# Non-Material Amendment Details

**Site:** 102-124 Station Road, Edgware HA8 7BJ

**Job No:** 14775-1

GENERAL CONSTRUCTION CHANGES TO THE STAIR CORE AND INTERNAL WALLS FOR THE ORIGINALLY PROPOSED UNITS AND SOME WINDOWS REMOVED/INTRODUCED

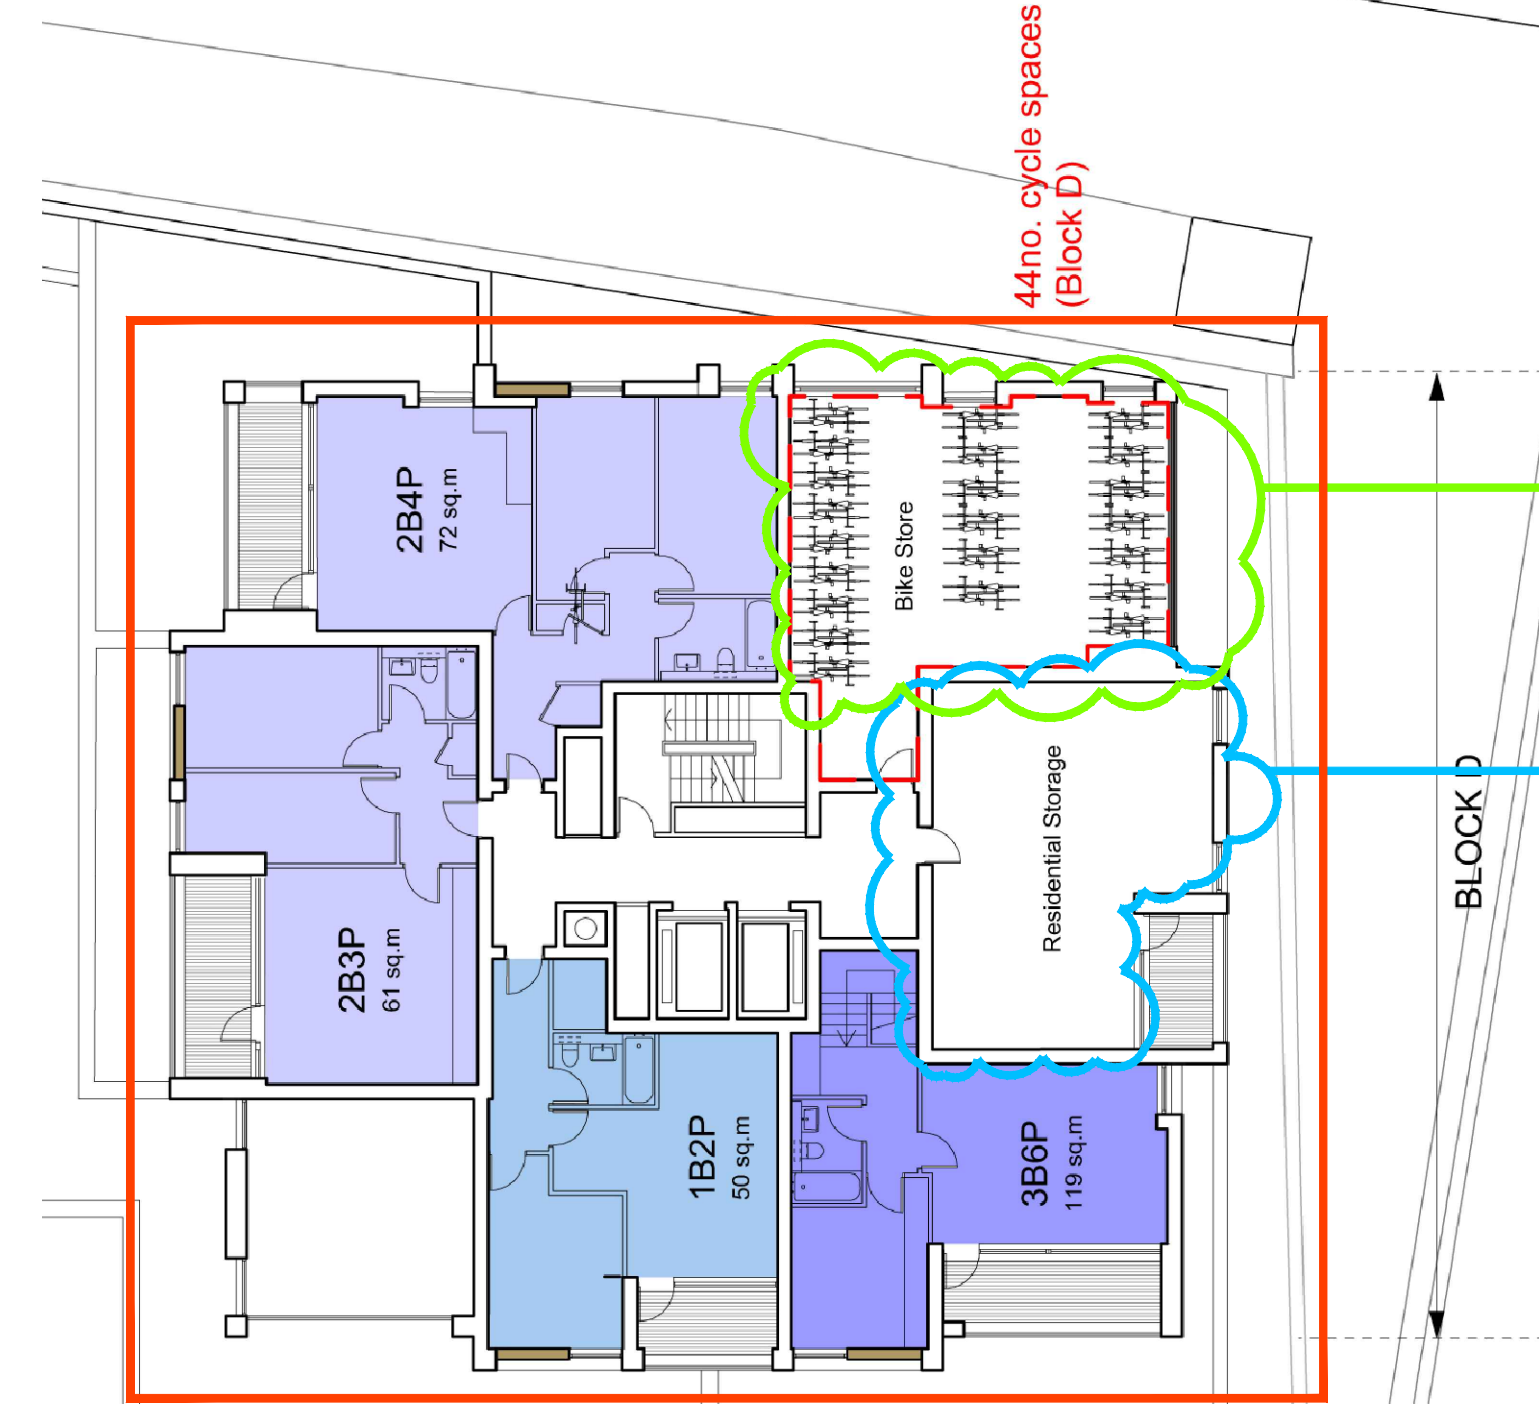
Two additional flats have been added to the 2nd floor layout of block D in place of a cycle store with 44 spaces and a storeroom. The total number of flats in the development will increase from 122 to 124.

Added to the 1st floor level of block D, are a revised cycle store with 86 spaces, Two new landlords' storerooms and new concierge facilities. This is in place of a cycle storage area with 88 spaces and a segment of a large lobby space for the concierge.

Drawing Number
24343-TUR-DR-08-04

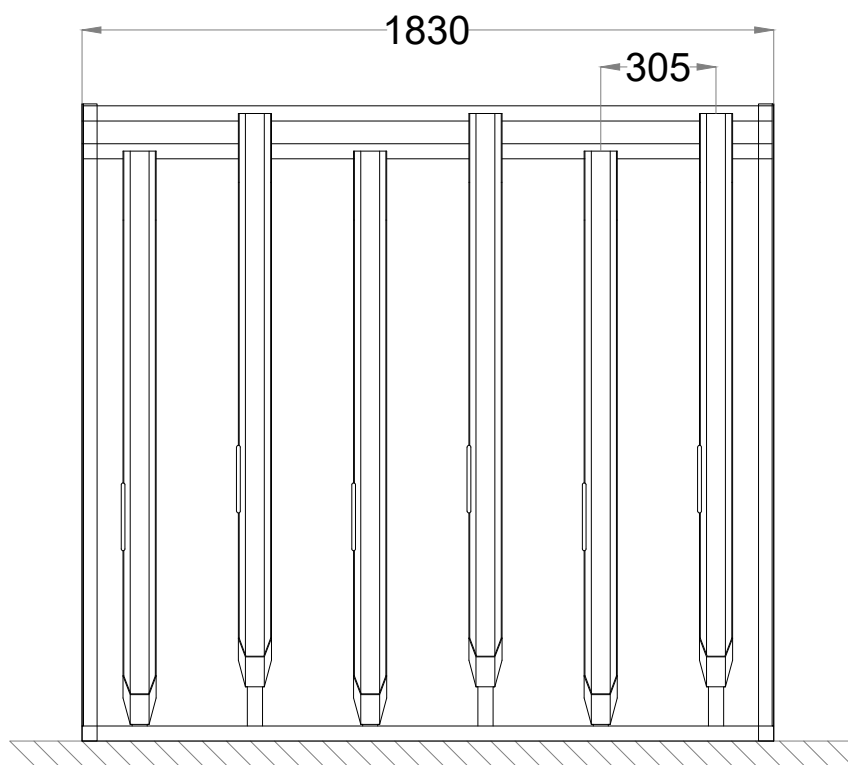
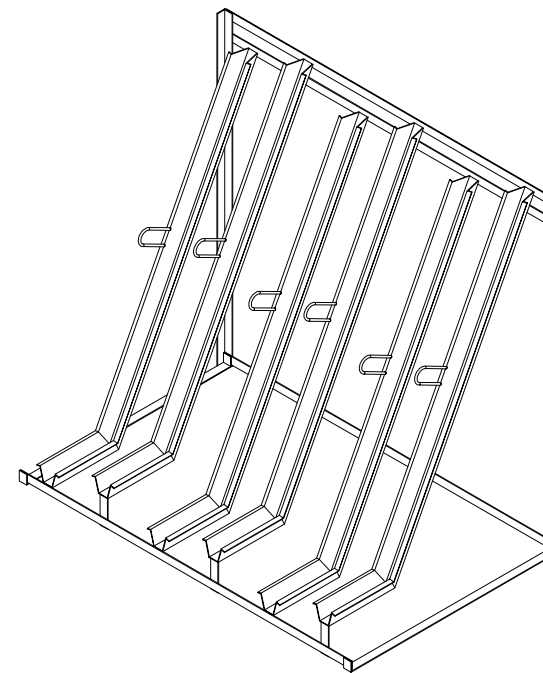
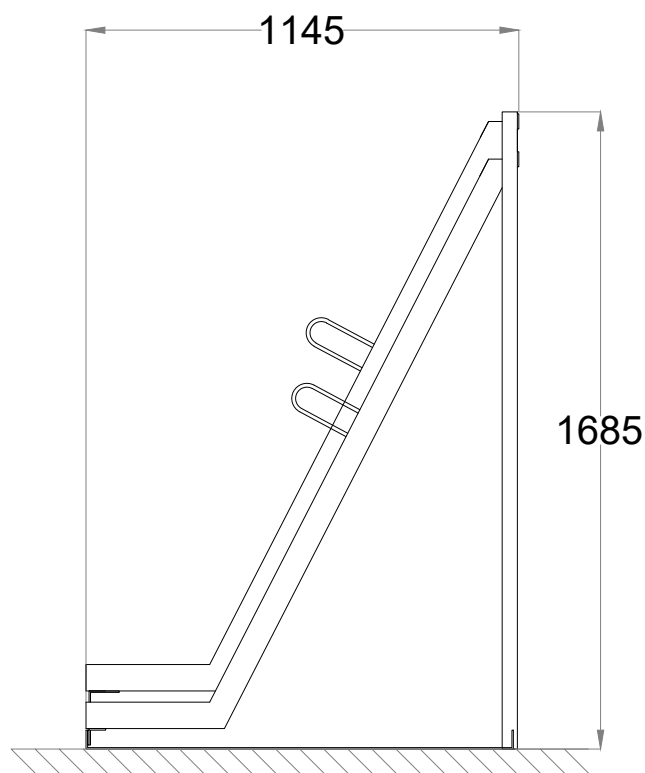
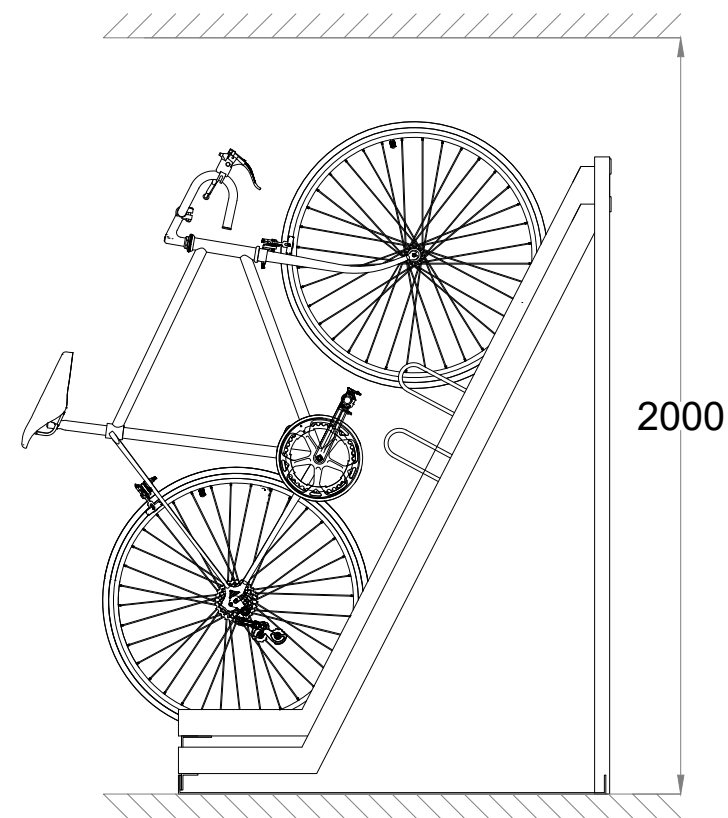
The ground floor block D cycle store has 54 spaces and Improvements have been made to the cycle storage at the ground floor level generally. The required area has been rationalized and is now housing a mix of cycle stands to suit all needs. Dual height cycle storage racks, semi vertical racks and Sheffield stands to all storage areas.
